CITY OF ALBUQUERQUE

December 15, 2017

**RE: Eagle Ranch MVD-Retail (Phase 1: MVD Building)
Eagle Ranch Rd (Tract C, Cottonwood Pointe)
Request for Certificate of Occupancy – Temporary
Hydrology Final Inspection - Disapproved
Engineer's Stamp Date 8/22/17 (B13D002C)
Certification Dated: 12/14/17**

C-2.0

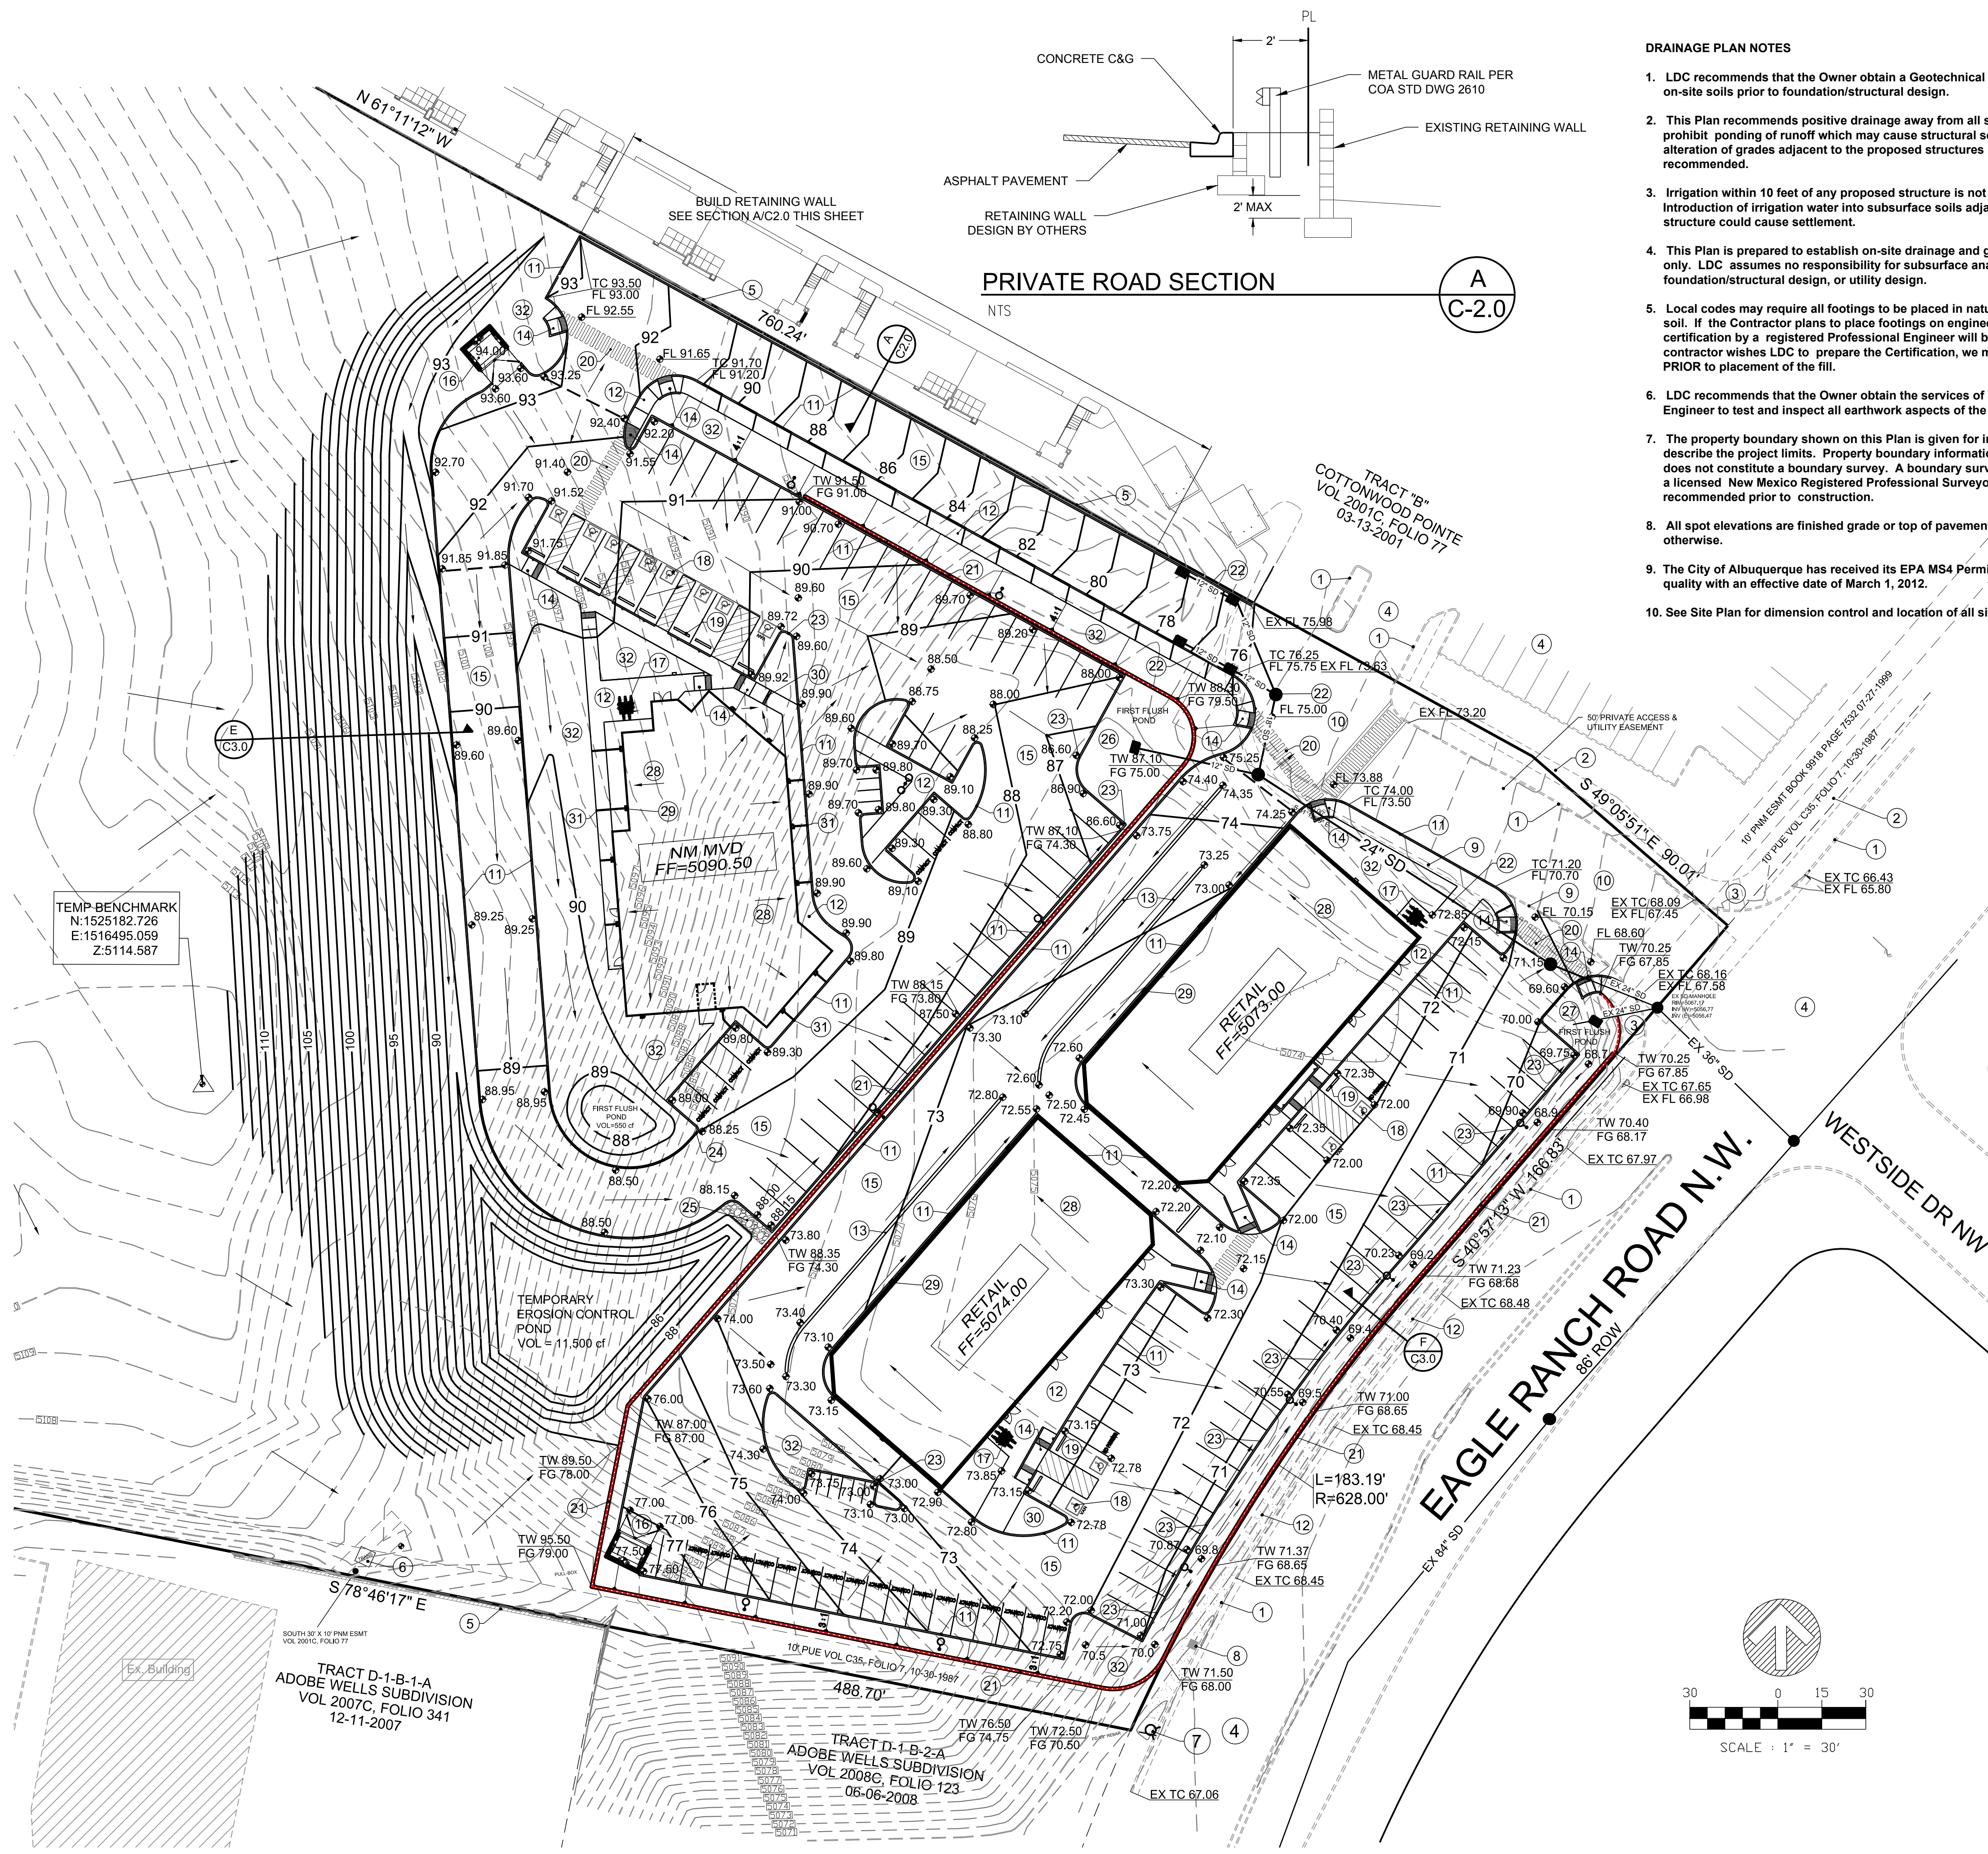
Based on the certification received 12/14/17, this submittal cannot be approved for release of Certificate of Occupancy by Hydrology. Prior to Hydrology approval, the following items must be constructed according to the approved Grading and Drainage Plan:

1. All first flush ponds in Phase 1.
2. The temporary erosion control pond.
3. All temporary erosion control improvements.
4. The west loop road.
5. The south end of the retaining wall.
6. Site landscaping as it pertains to stabilization and erosion control; i.e., gravel mulch on slopes.
